September 19, 2024

File: 100143.003 – Rev0

**Re: GEOTECHNICAL GRADING REVIEW
PROPOSED RESIDENTIAL BUILDING
788 MARCH ROAD, OTTAWA**

Scale: 1:300	Project Number: CO-24-1519
Drawn By: RP	Checked By: JH
Designed By: RP	Drawing Number: C101

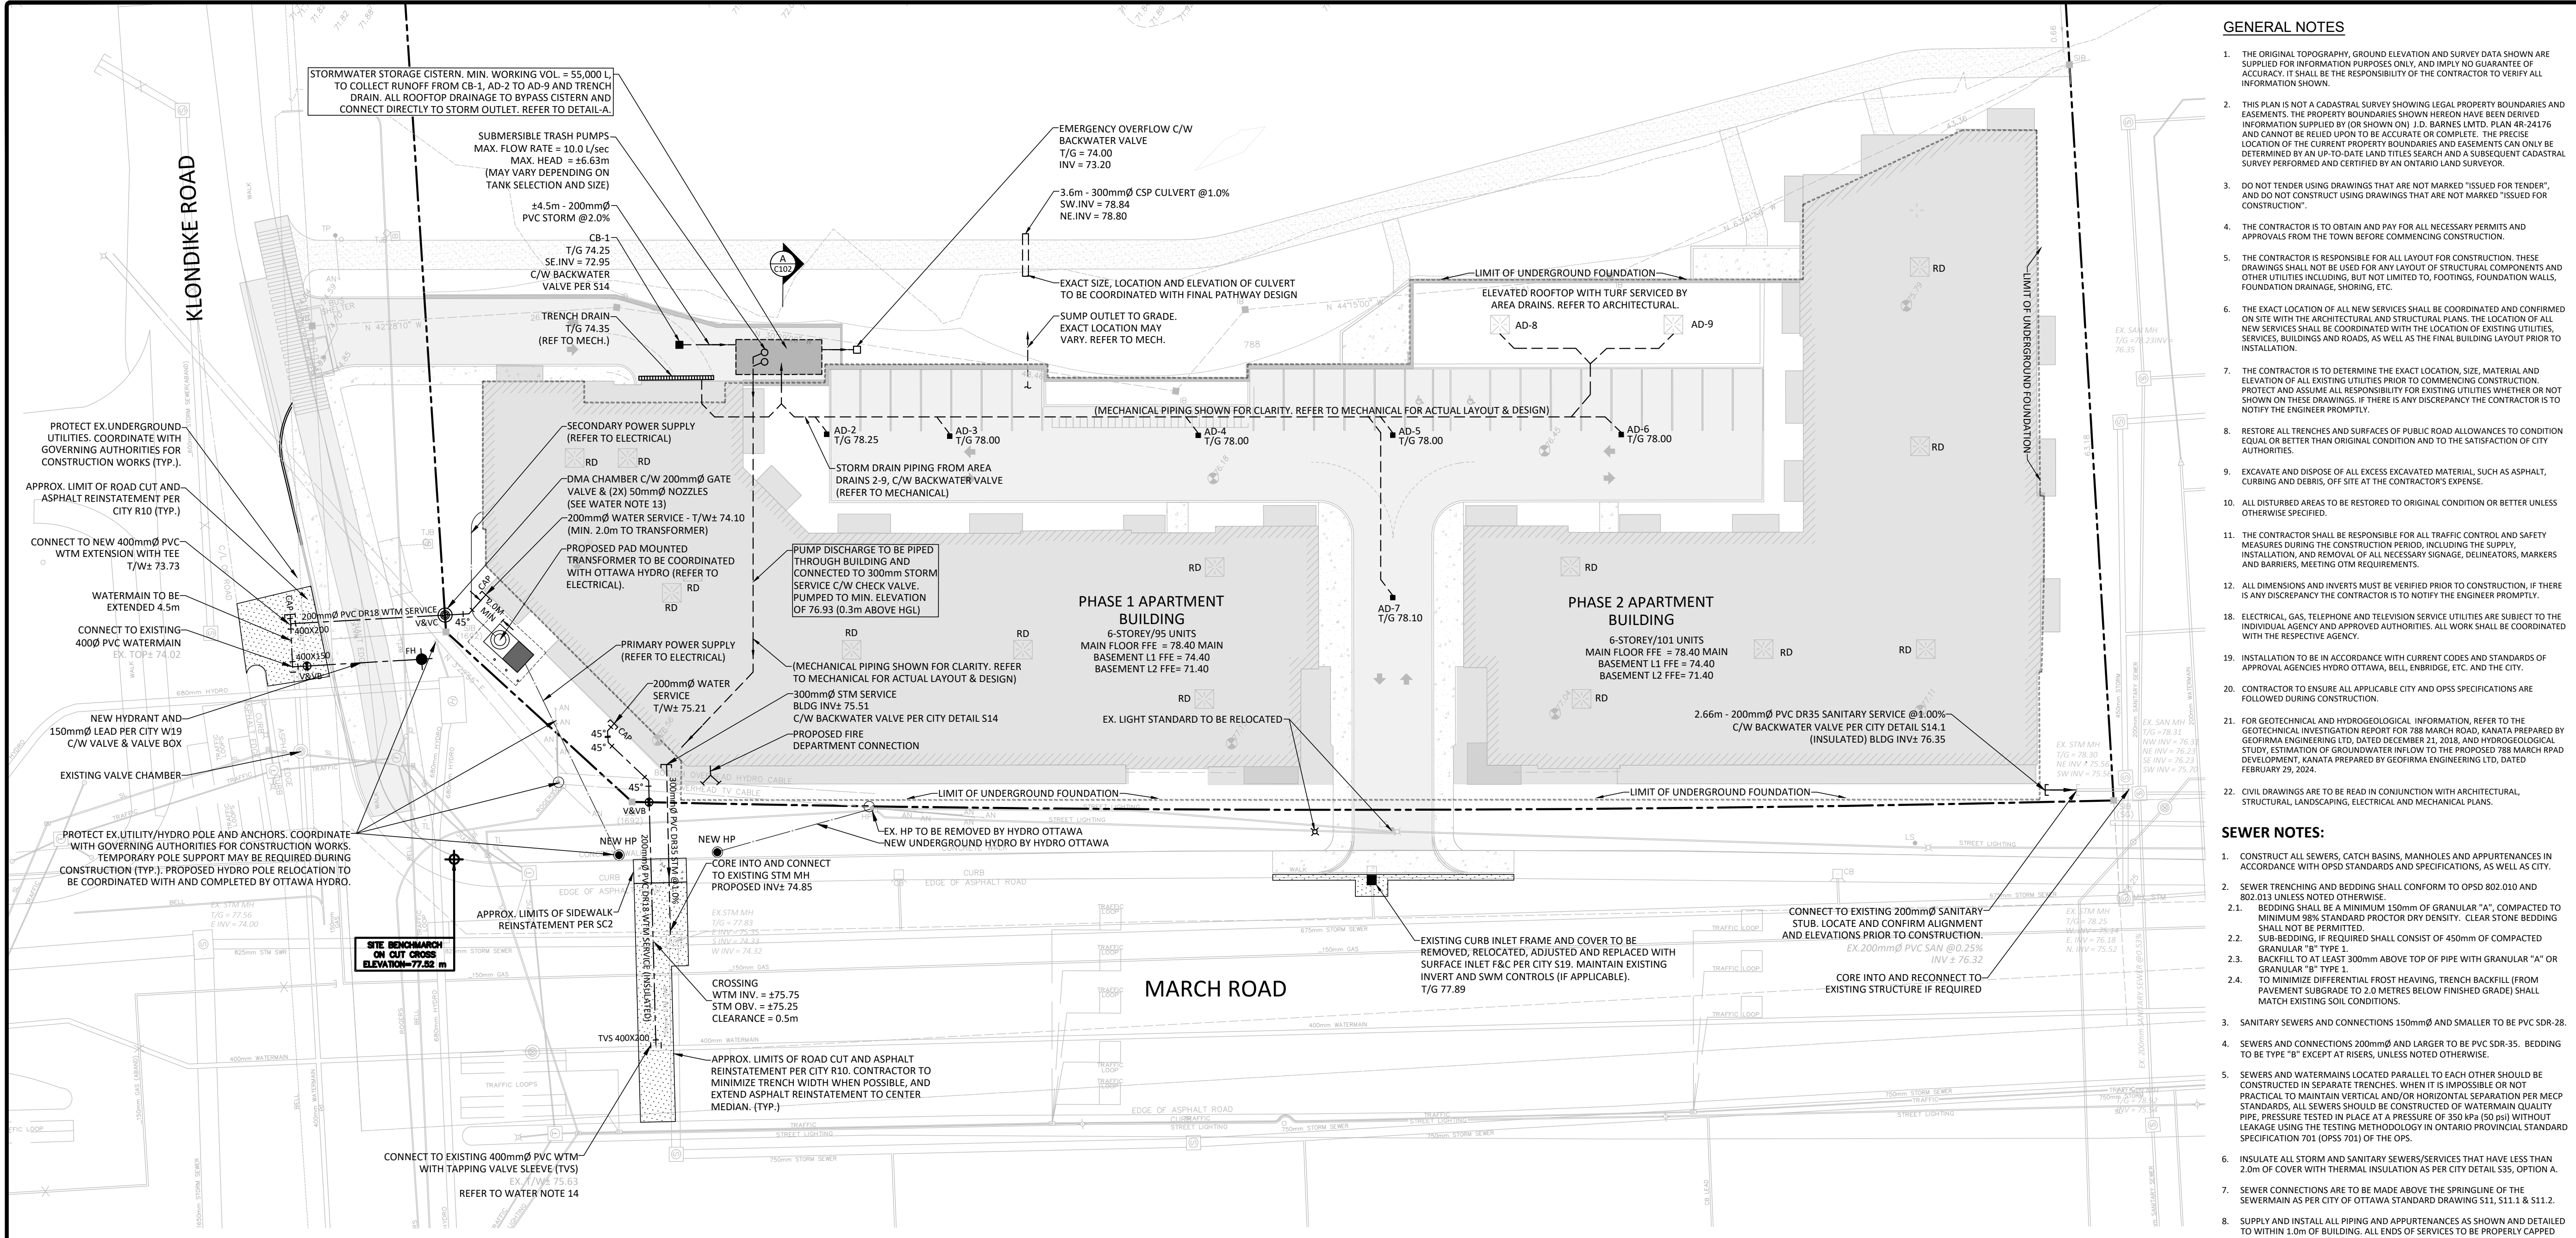
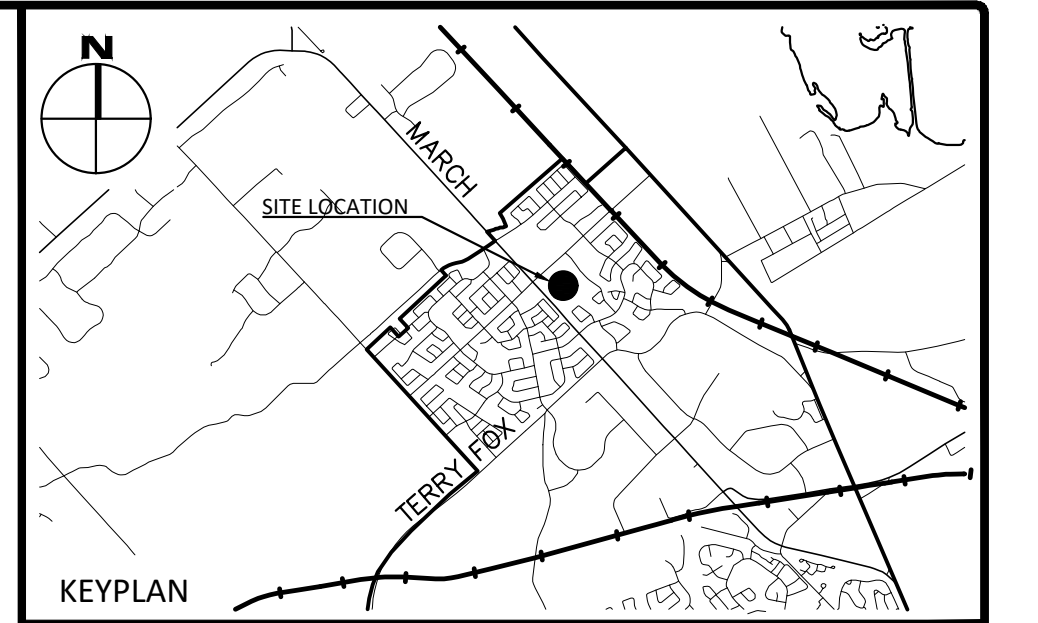
GEMTEC was provided the Site Grading Plan (Drawing Number C101, dated August 26, 2024) prepared by SINA which indicates that the changes in grade on the site will range from minor cuts, about 0.3 m metres in depth, to fill heights of no more than about 1.3 m.

The planned grade raises are therefore in conformance with the recommendations provided in GEMTEC’s geotechnical report.
